Application for Removal or Variation of a Condition following Grant of Planning Permission or Listed Building Consent

Demolition of existing single garage and sheds. Construction of a double garage with ancillary home office

22/01925/APP

2 and 3

Drawing: Revised Fenestration & Materials

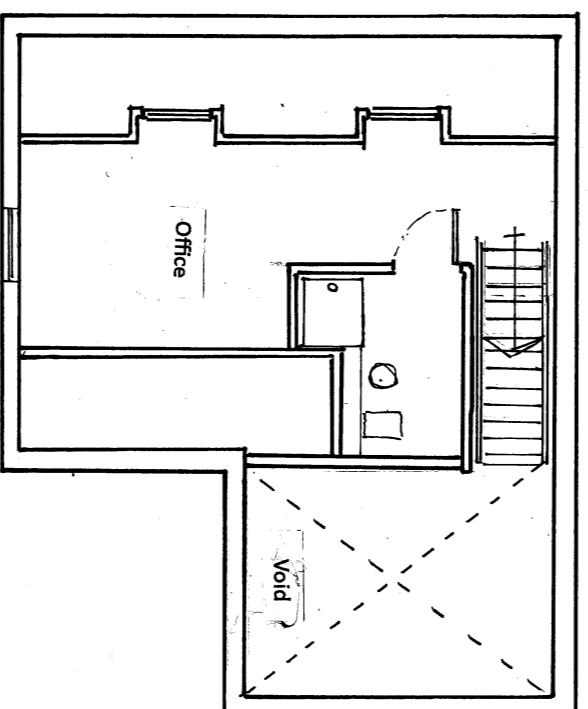
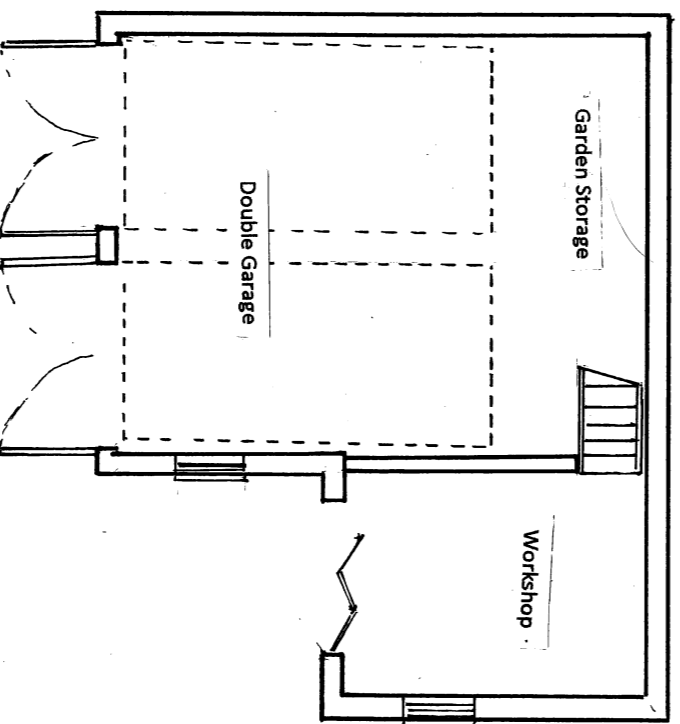
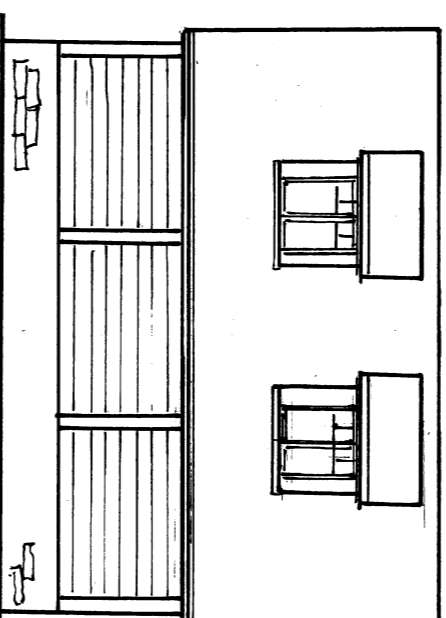
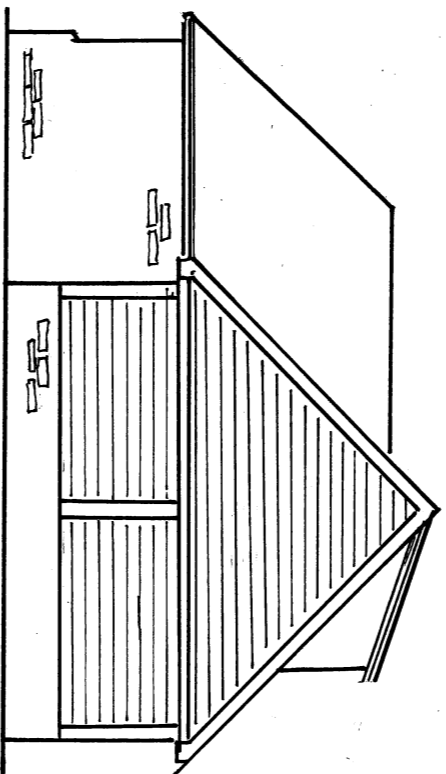
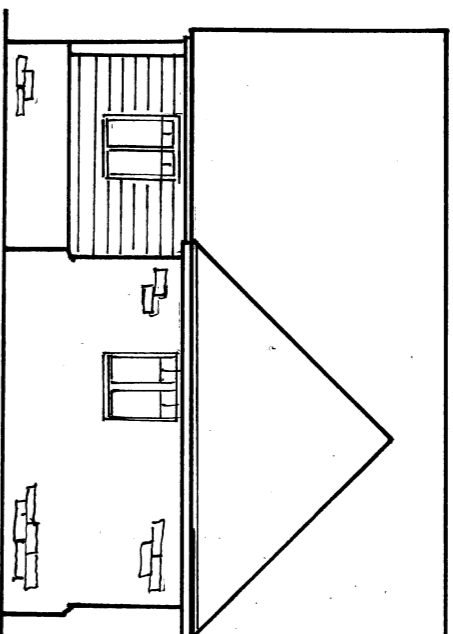
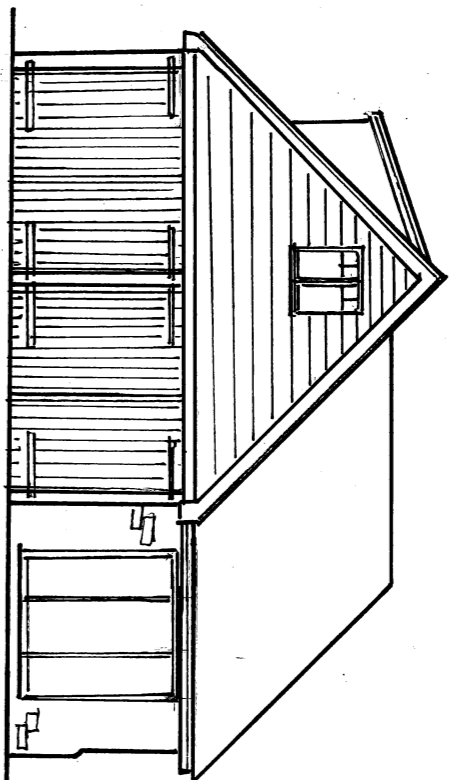
One of the approved workshop windows (south-west elevation) has been omitted. Approved door and window on north-west elevation of workshop replaced with single 'cart style' glazed opening. External walls of workshop to be brick (multi red, as approved for plinth) instead of timber cladding above plinth.

Condition 3 - The materials to be used in the development shall be as indicated on the approved Plans & Elevations - Revised Fenestration and Materials dated November 2023
